File 56.5395 09/3; C10/670

**Rasp Project (07_0018) Broken Hill
Exhibition of Environmental Assessment**

Tony Hendry
Road Safety and Traffic Manager
Western

Figure 14-2 Trucking route through Broken Hill

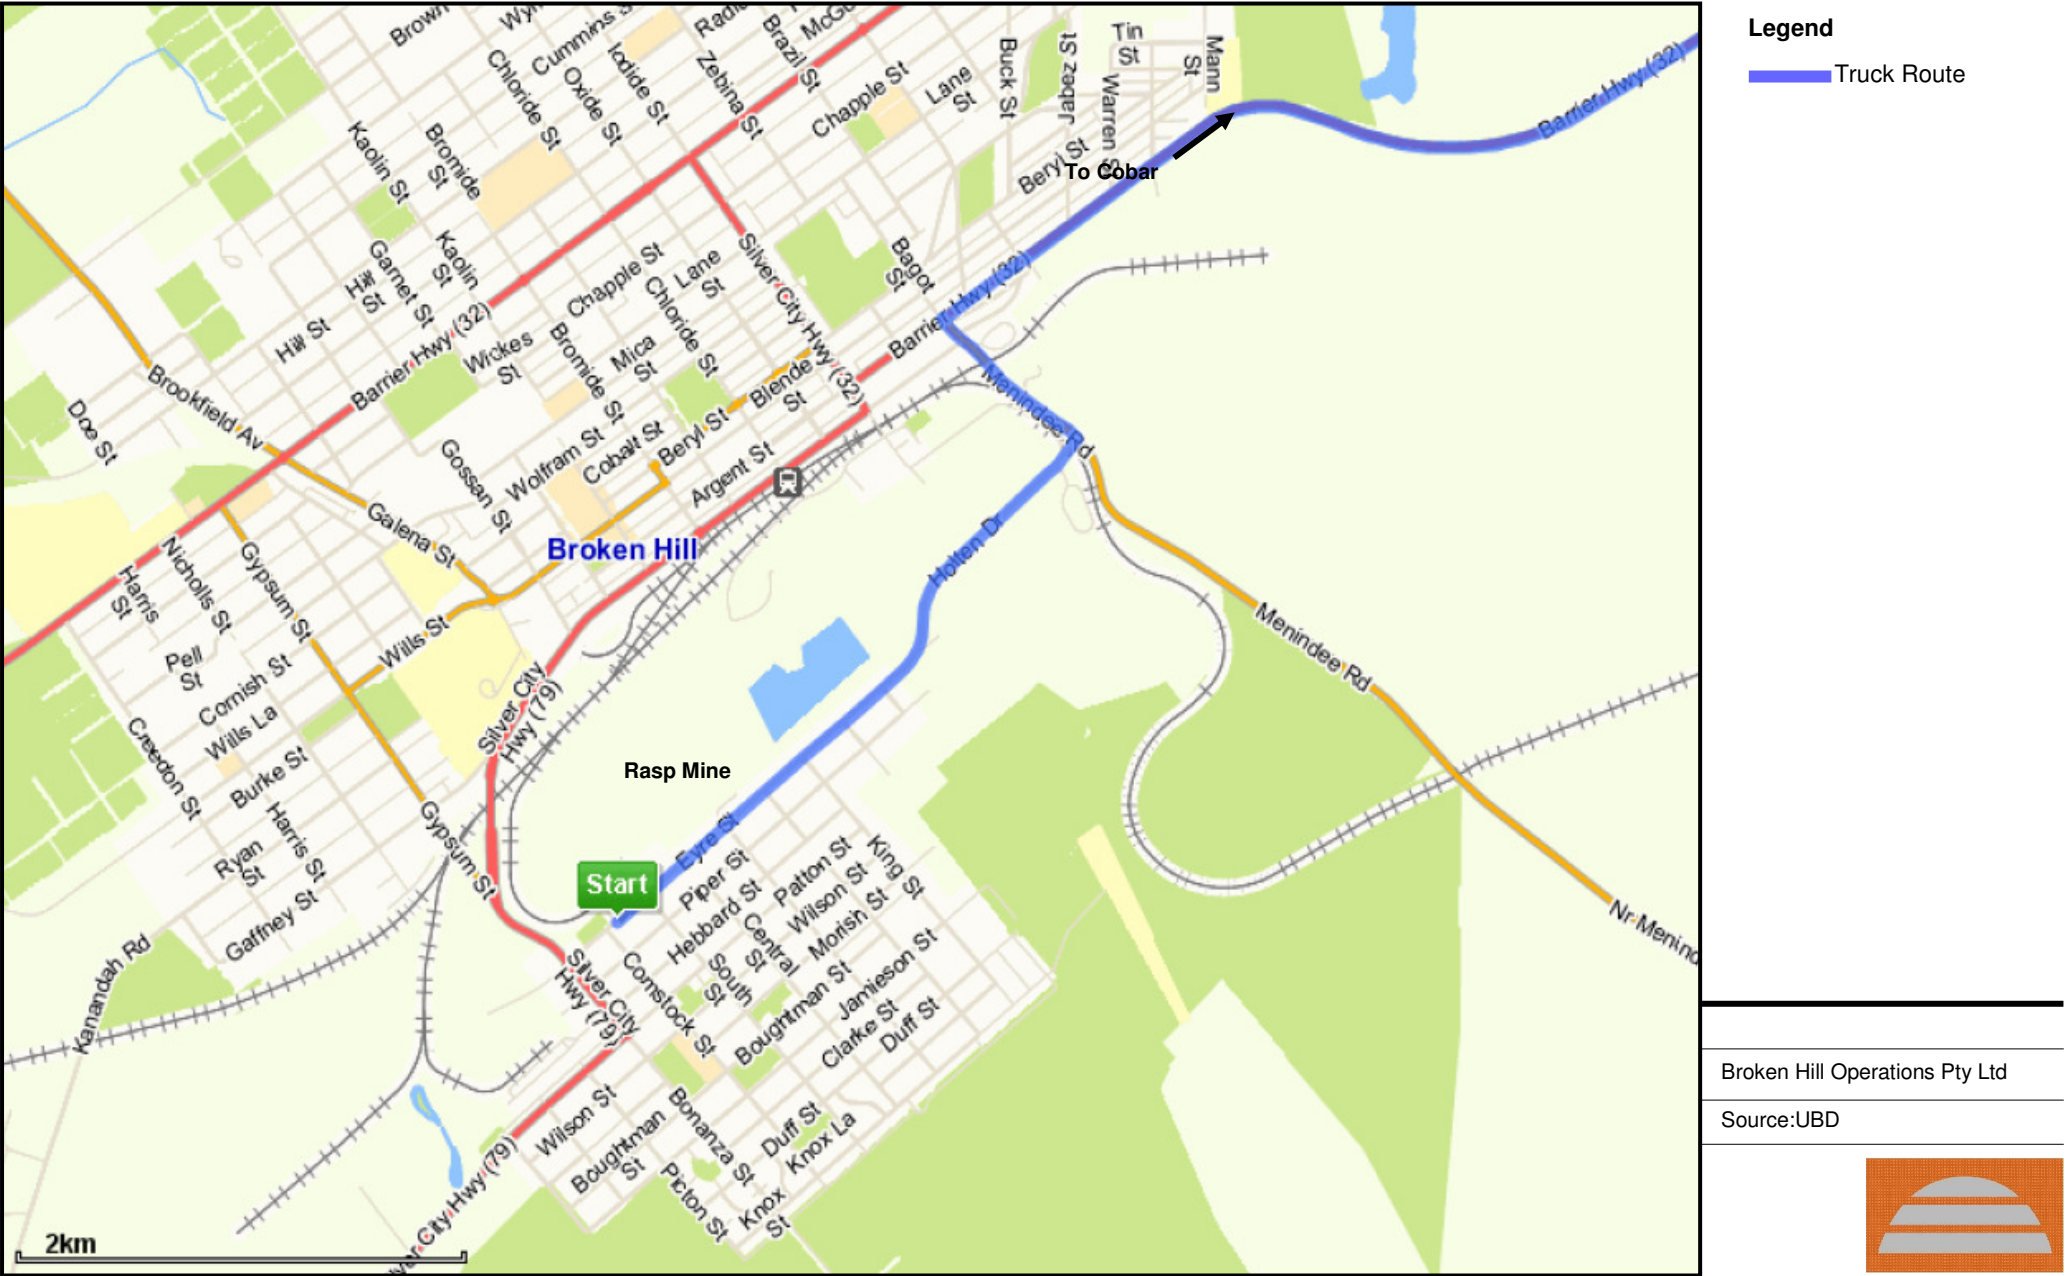
1. Should crushed ore during the construction stage need to be transported other than during daylight hours the RTA will require lighting of the intersections in accordance with AS 1158 where the transportation route turns left or right at intersections. Costs involved in maintenance and power for this lighting is the responsibility of the proponent.

2. The Eyre Street access modification should be in accordance with the recently approved DA264/2009. Turning paths are to be provided to demonstrate that the proposed haulage/delivery/construction vehicles will be able to turn left into or out of the Eyre Street access without crossing the centreline of Eyre Street. (Dot point 2 above refers).

3. The South Road access is to be used only by oversize trucks which can not negotiate the internal road system from the Eyre Street access. It is noted that a safe entry/exit procedure will be implemented and

will form part of the overall traffic management plan for the site. A copy of the management plan is to be submitted to the RTA for approval.
